WEST SUSSEX COUNTY COUNCIL CONSULTATION

TO:	Arun District Council FAO: David Spring
FROM:	WSCC - Highways Authority
DATE:	7 May 2020
LOCATION:	Land adjacent to Sefter School House, Sefter Road, Bognor Regis, PO21 3EE
SUBJECT:	P/116/19/OUT Outline application with all matters reserved for the erection of 4 No. semi-detached 3-bedroom houses & 2 No. detached 4-bedroom houses with associated access, parking & gardens. This application is a Departure from the Development Plan.
DATE OF SITE VISIT:	N/A
RECOMMENDATION:	Advice
S106 CONTRIBUTION TOTAL:	N/A

Proposed Site Access Arrangements

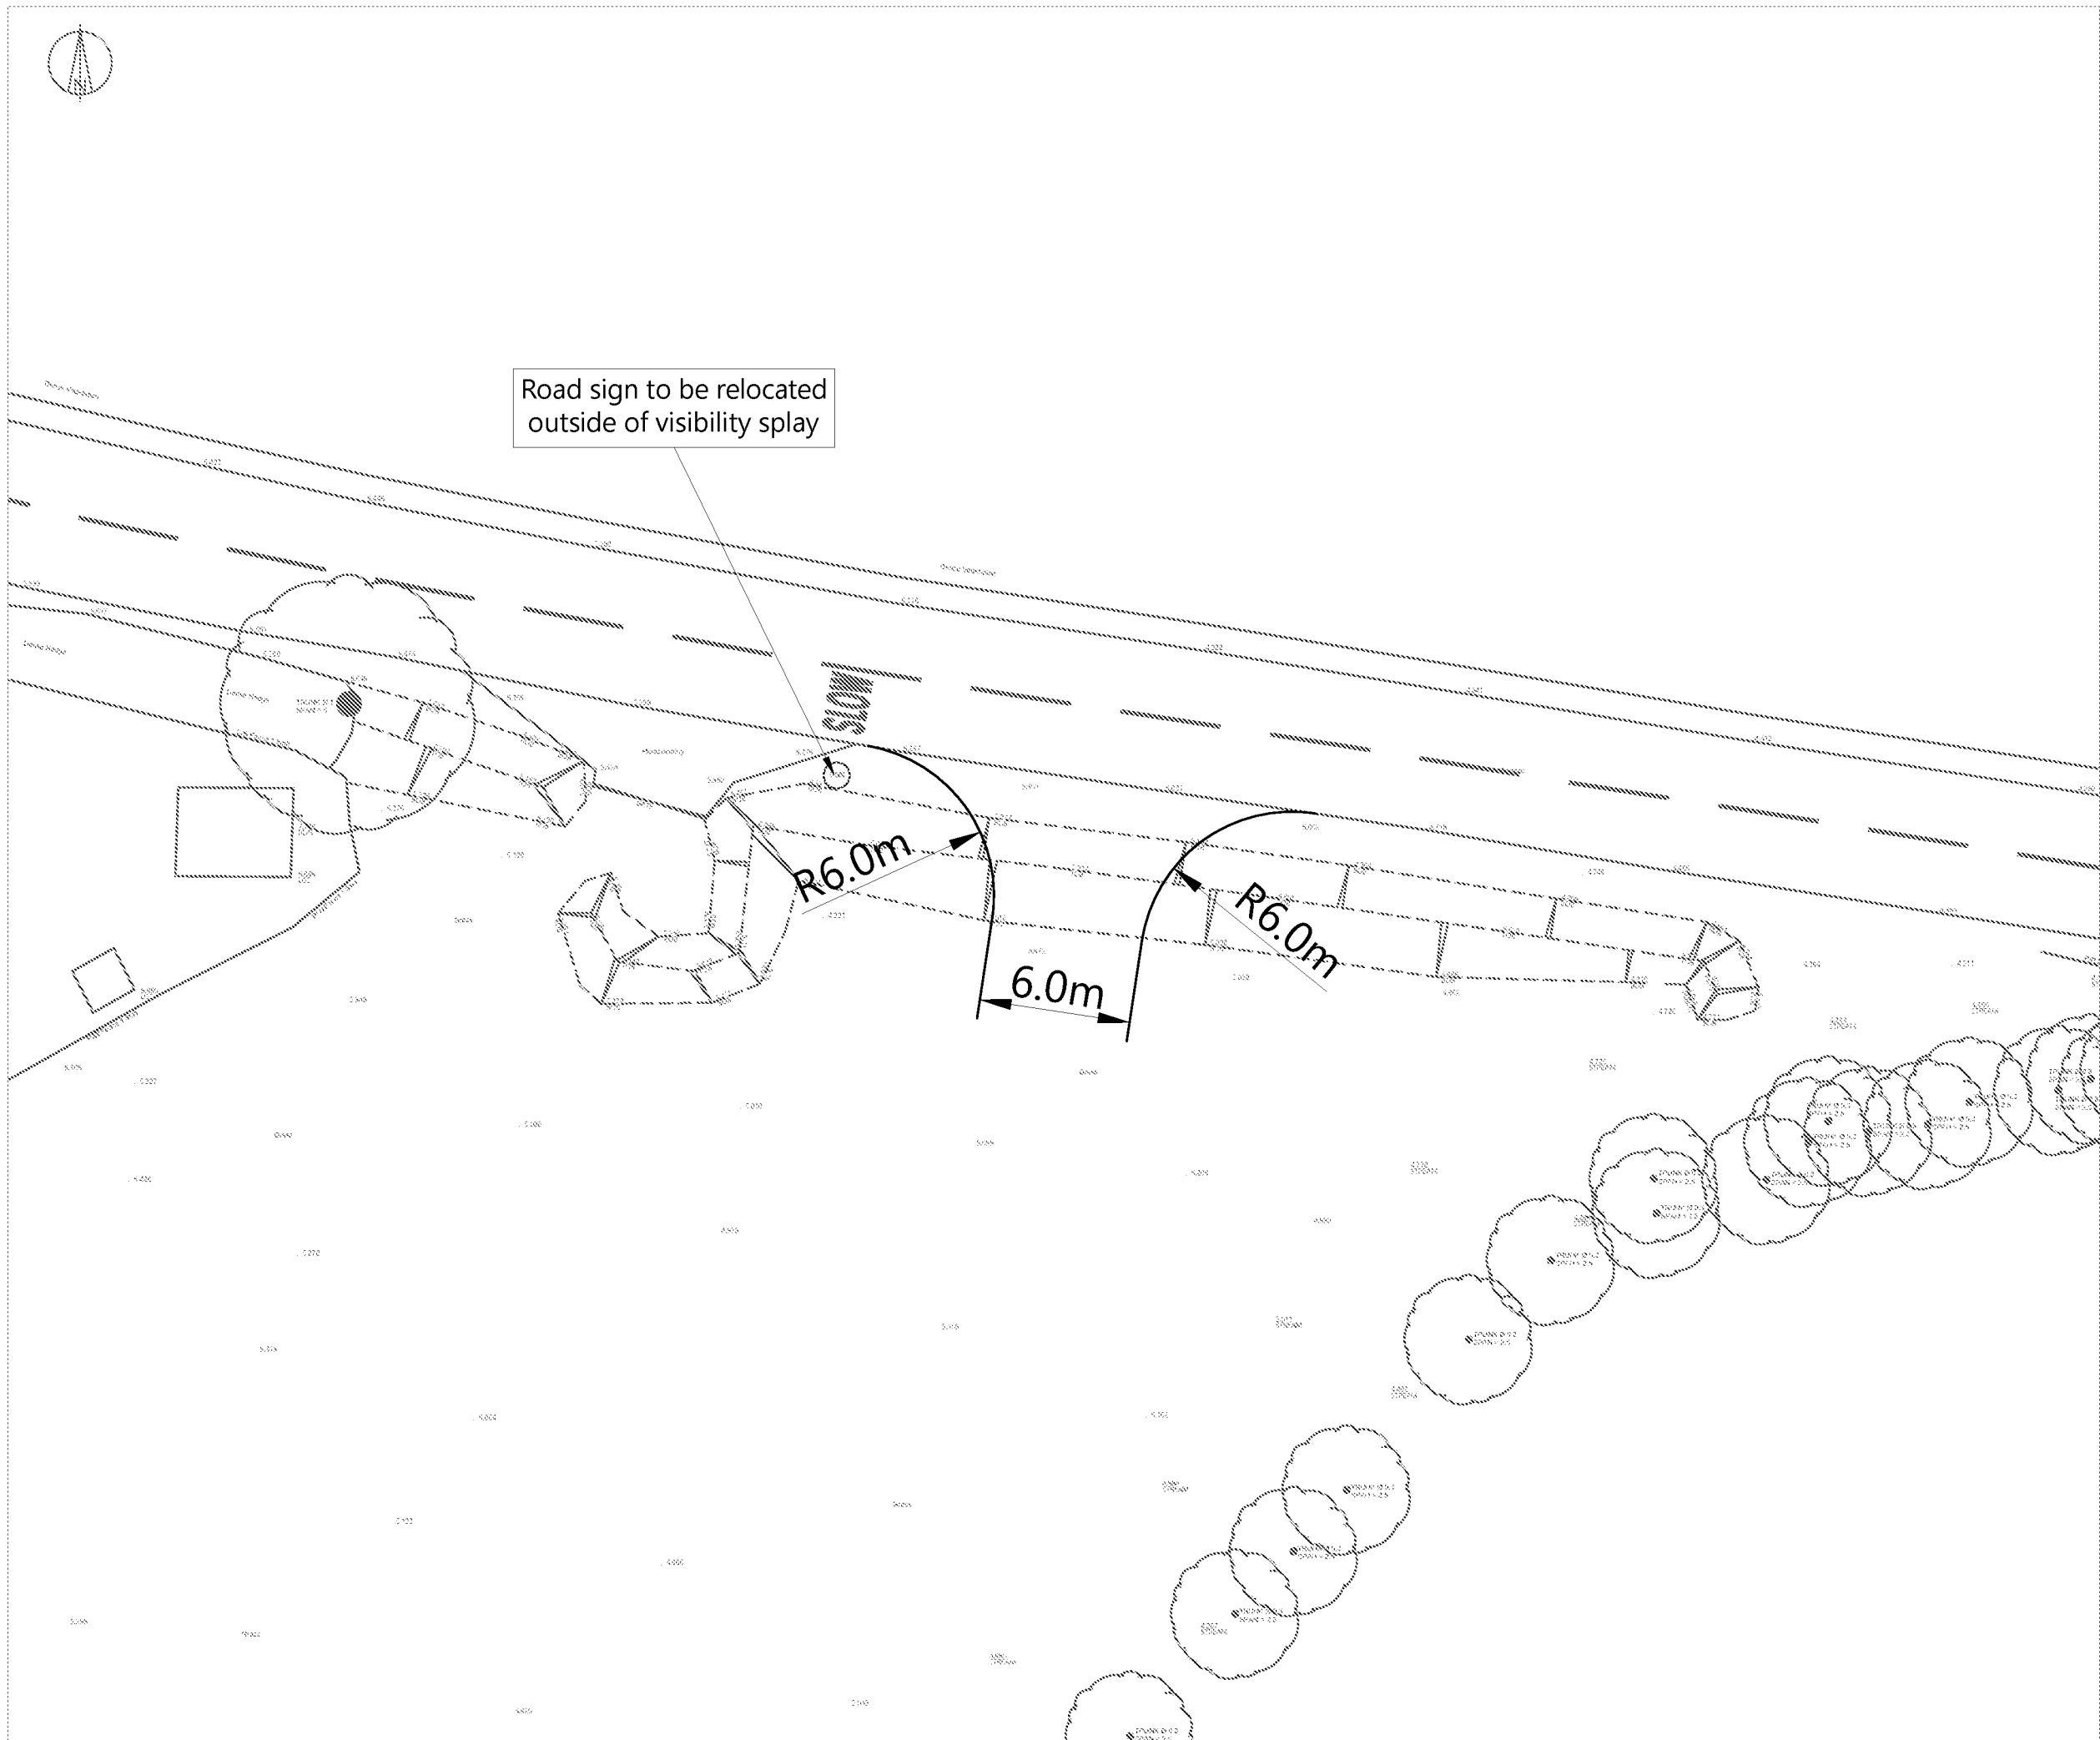
It does not appear that the applicant has clarified if they wish to implement a Vehicle Crossover (VCO) License or a Section 278 Minor Works agreement for the access works. For the LHA to recommend the correct route to progress with, we ask if the applicant can clarify the route in which they wish to take.

Visibility Splays of Proposed Site Access

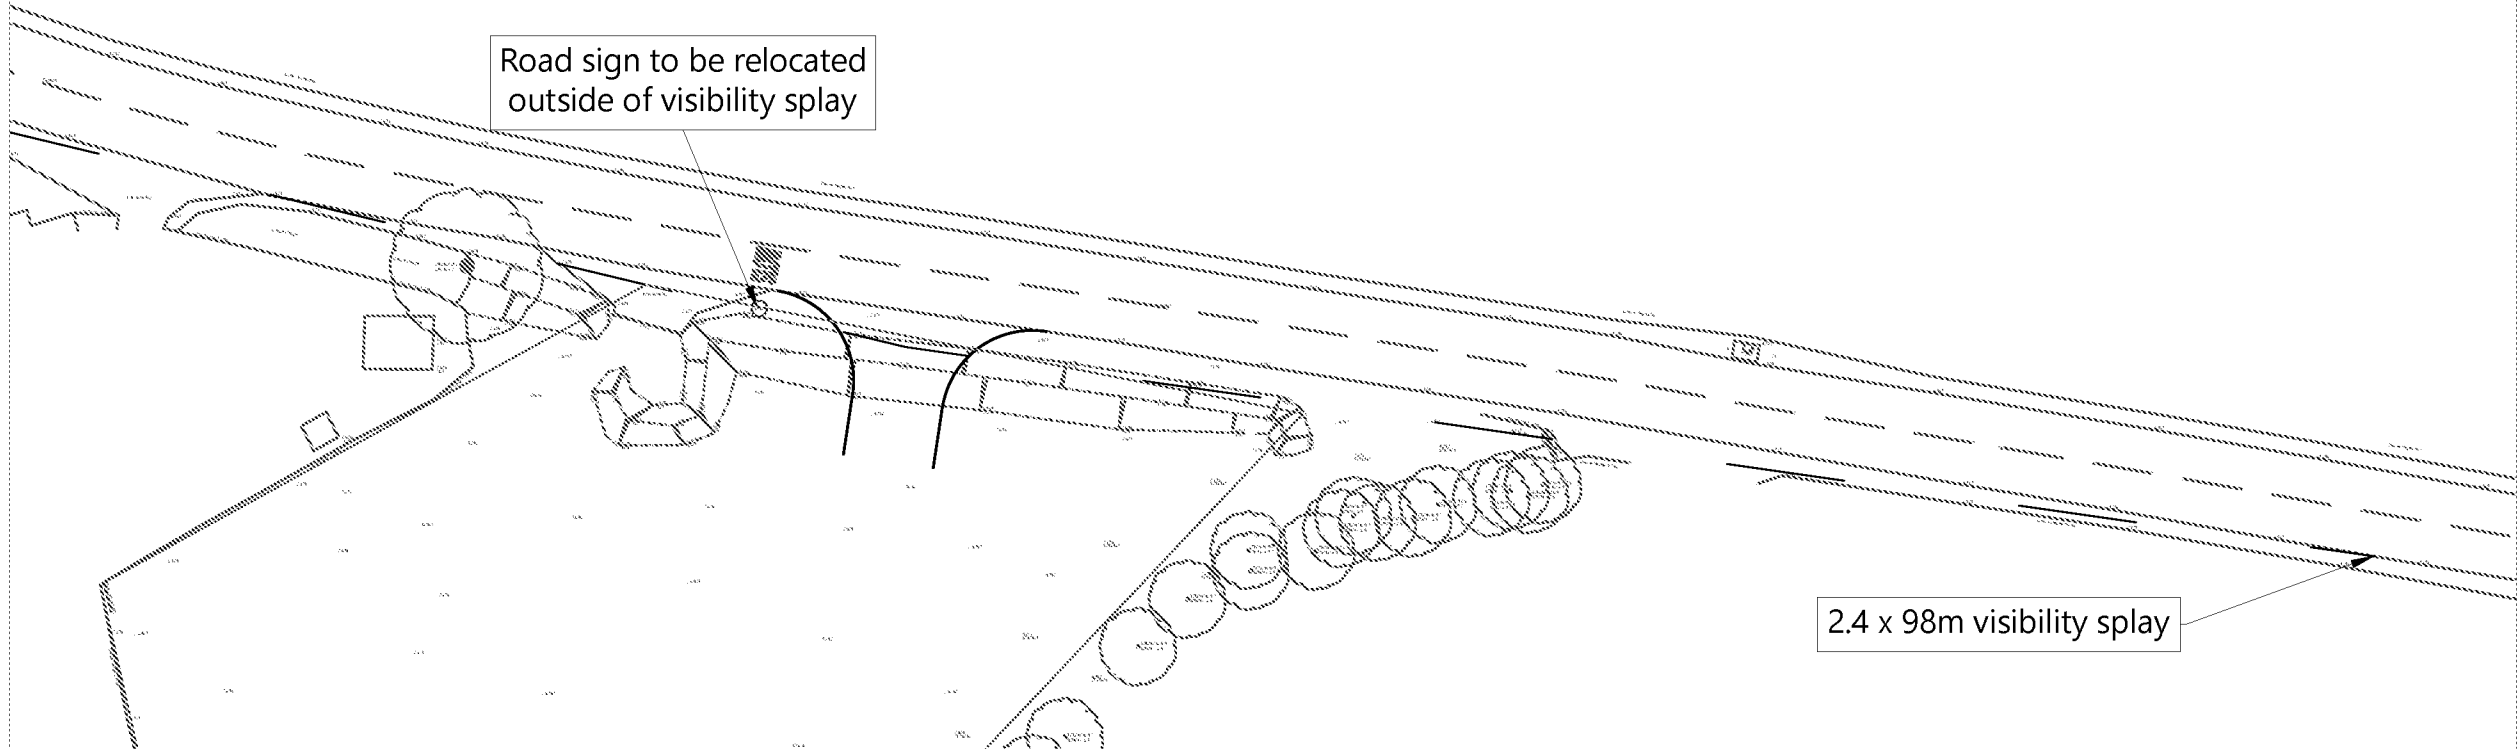
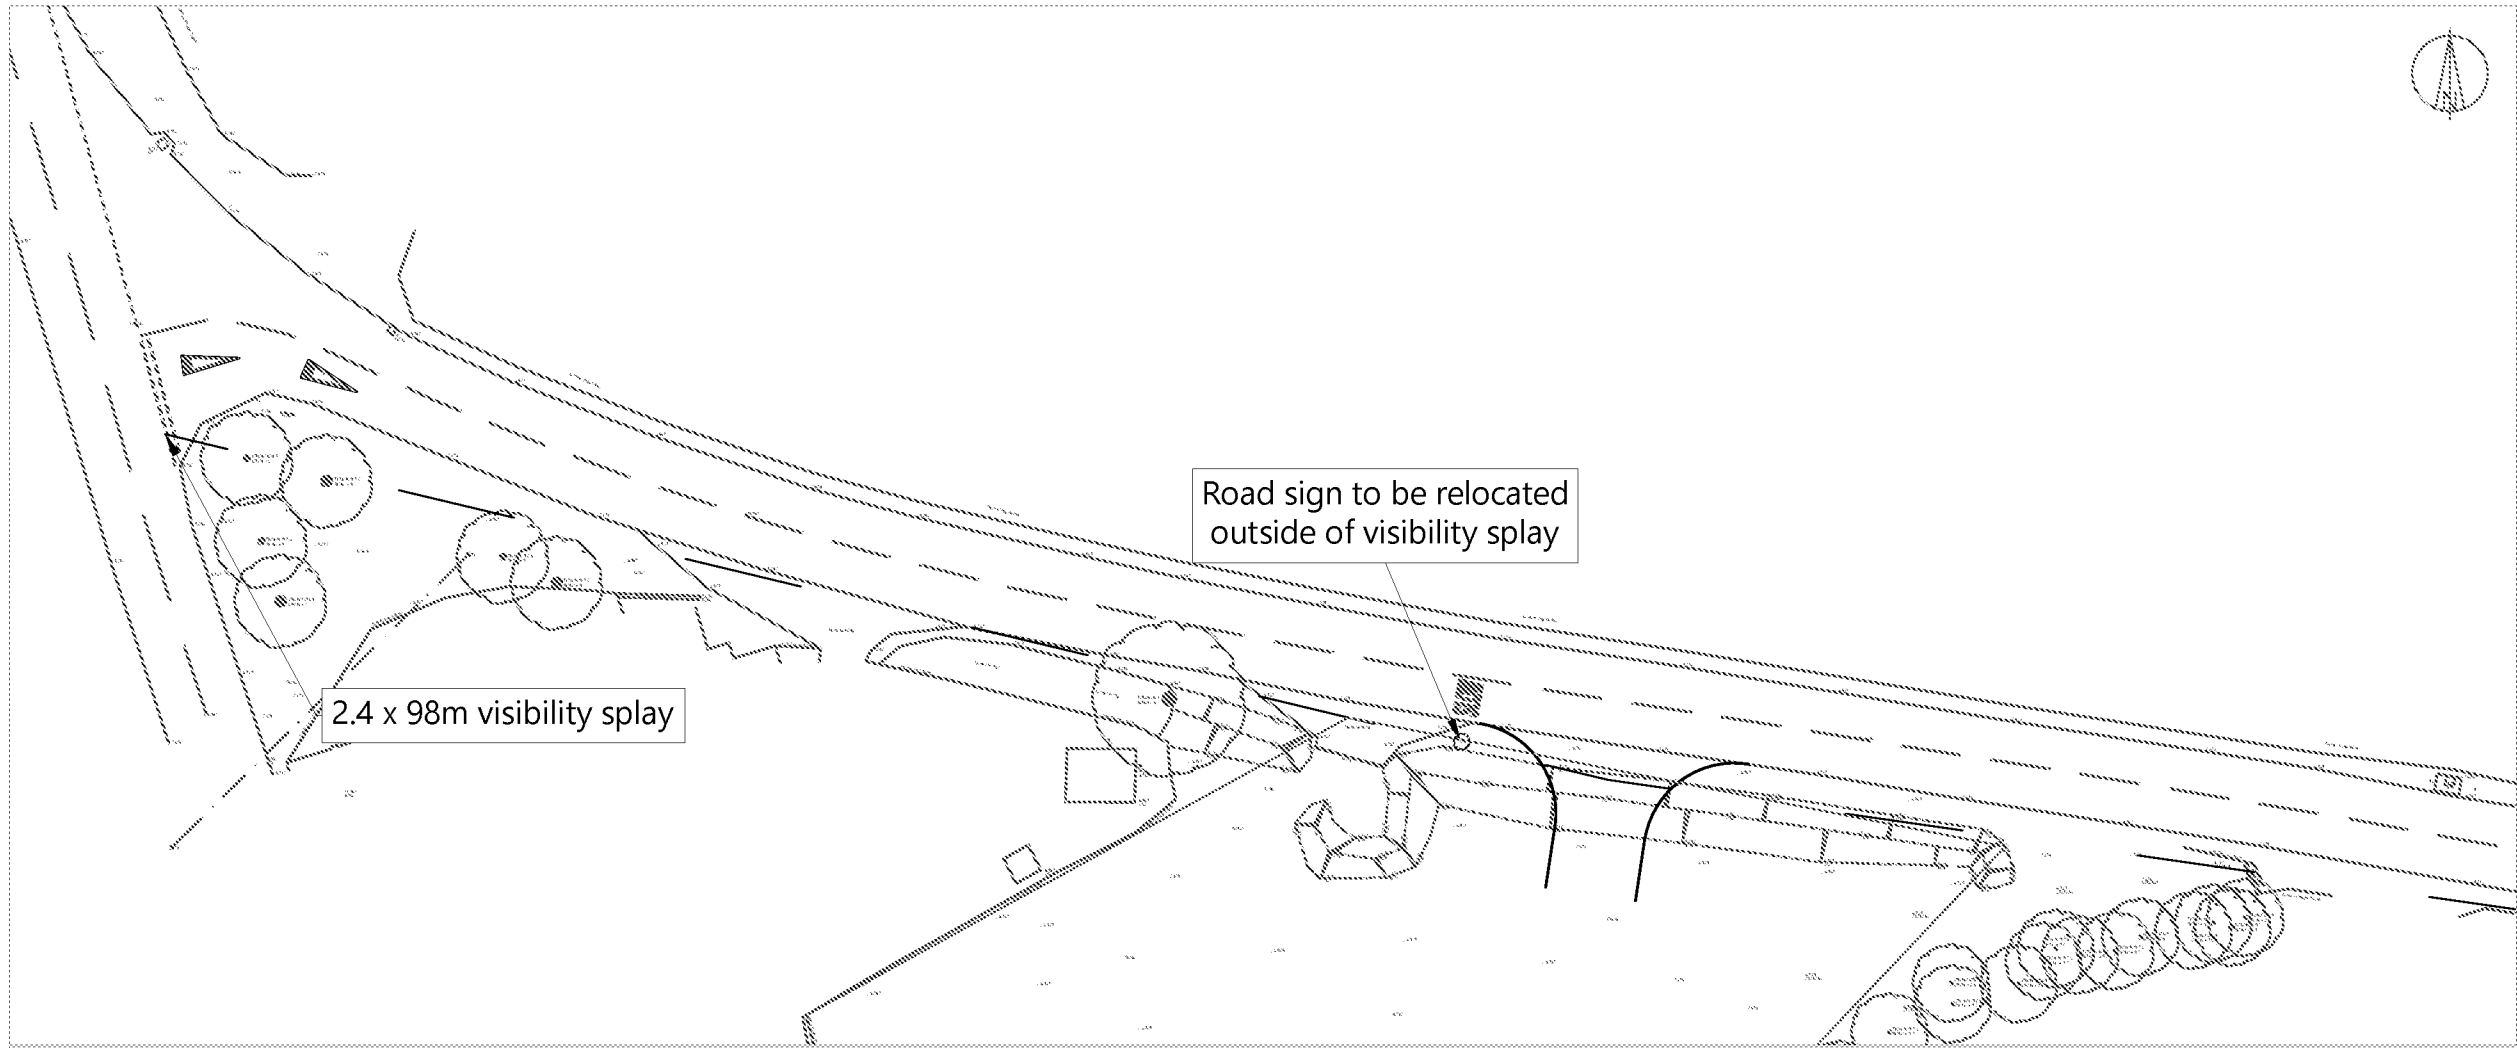
The applicant has not demonstrated maximum achievable visibility splays at either the existing or proposed access points. For the LHA to consider the suitability of a new access we would request these details to be provided.

All Visibility splays must include a 2.4m setback distance from the kerb edge of the footway and span in both directions to the kerbed edge. The splays must not intersect third party land, be located solely within land under the control of the applicant or within the Publicly Maintained Highway, and include the current road geometry. We have provided a diagram below for your guidance only.

The LPA and Applicant should be advised that depending on the result of such information that the LHA may require an additional 7-day speed survey to be conducted.
